RESPONSE TO SUBMISSIONS REPORT

Modification for New Public School in Mulgoa Rise - SSD 11070211-
Mod-1

12 August 2022

**Figure 2: Proposed Development.**

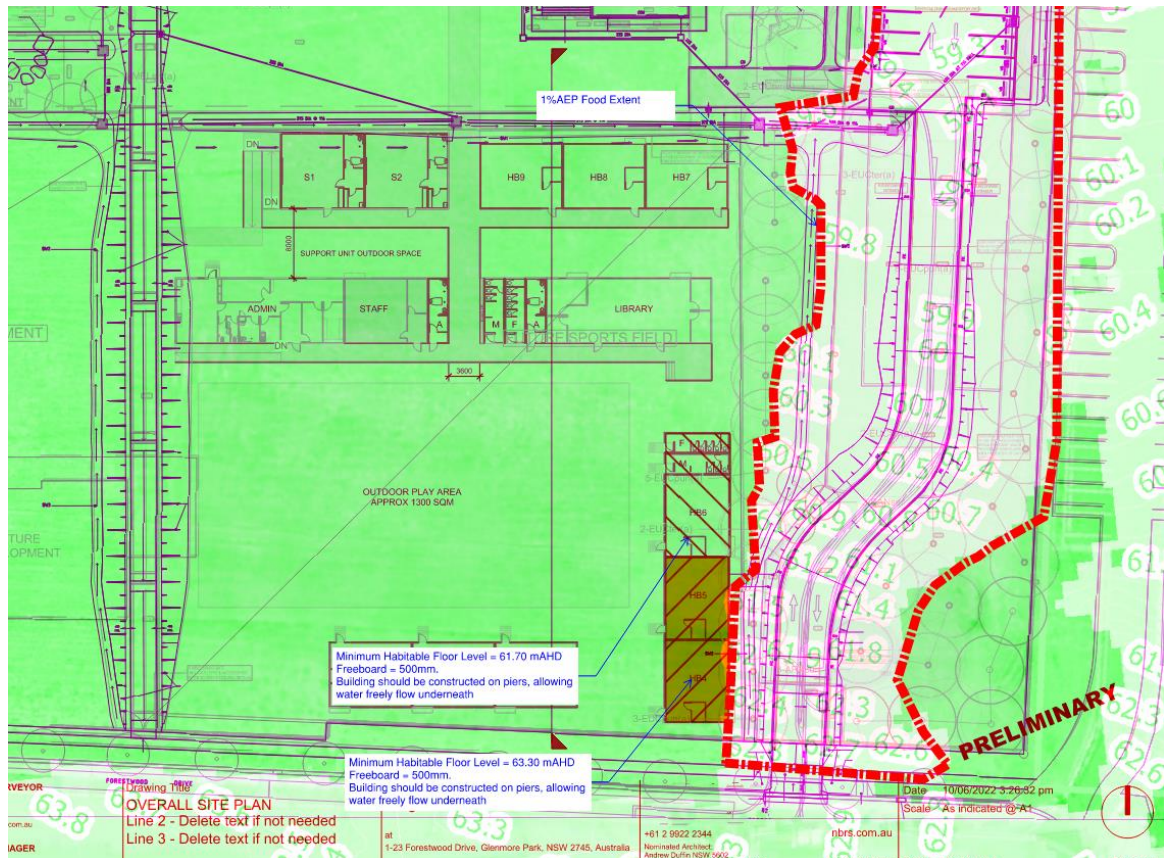
Assess flood behaviour on-site and in the surrounding areas post-development of the proposed temporary buildings, for both the PMF and 1% Annual Exceedance Probability events. Clearly state whether the proposed temporary buildings would result in any additional flooding to surrounding properties.

The design and minimum habitable floor levels of the buildings as submitted with the Modification Application are based upon the Updated Flood and Stormwater Management Advice Report. Any of the proposed buildings that lie within the PMF and 1% AEP flood event extent will be constructed on piers and therefore the temporary buildings will not affect the flood behaviour onsite or the surrounding areas due to the free flow underneath.

Drawing Reference  
**20415-NBRS-DW-AR-SSDA-0110012**

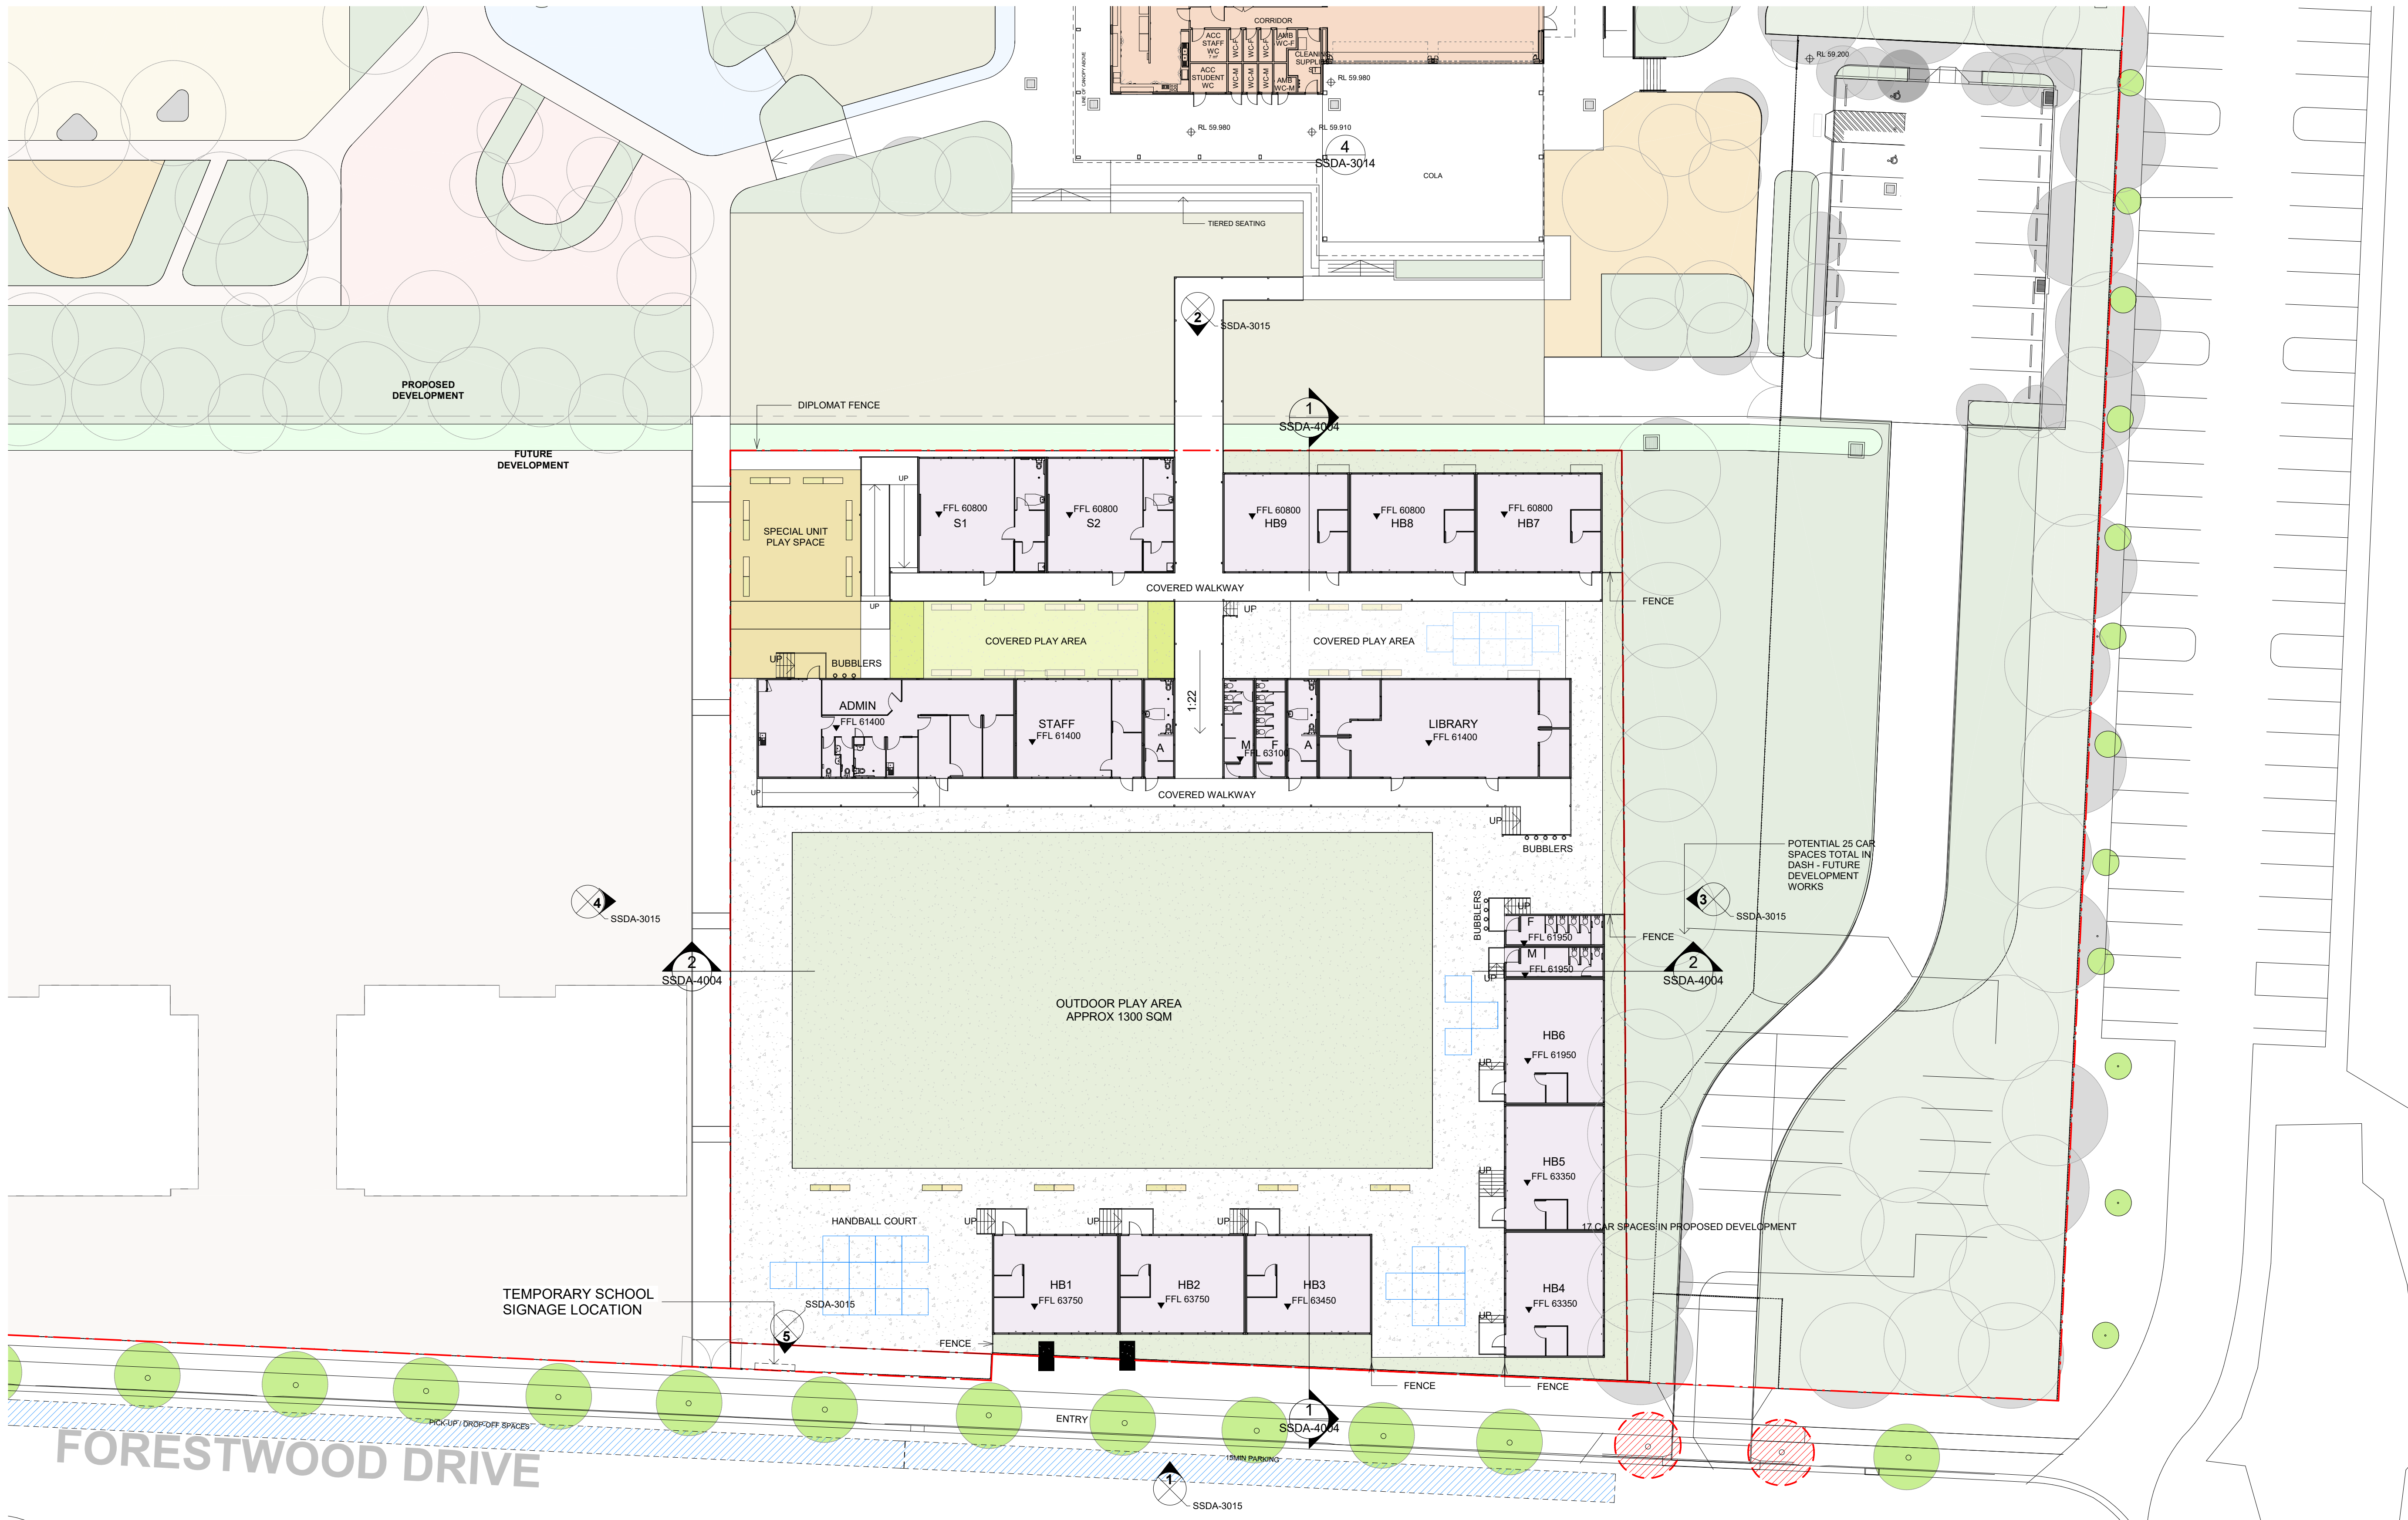
Comment/Issue	Response
Planning considerations	
The proposed setbacks of the demountable buildings from Forestwood Drive have not been nominated on the plans. The plans should be updated in this regard and consideration should be given to providing for street setbacks which, as far as possible based on available space, are characteristic of the dwelling setbacks on the southern side of Forestwood Drive.	<p>A plan showing the built form setback lines along Forestwood Drive is provided in Appendix C and an extract from it is provided in Figure 5 below.</p> <p>At the closest point to the southern boundary elements of the temporary school structures will be approximately 1.5 metres from the 2100mm high security fence. At this location it is noted that the boundary with Forestwood Drive is indented by 2 metres possibly reflecting the historic 20 metre road reserve against that of Forestwood Drive to the west of the Hassall Way intersection which has an 18 metre road reserve. Having regard for the boundary anomaly and the fact that residential development on the southern side is set back at least 3 metres from the road reserve, as illustrated in Appendix C and Figure 3, the distance of the temporary school structures from the southern boundary is considered appropriate based on the available space and the temporary nature of the development.</p>  <p>1 SETBACK PLAN 1 : 500</p>
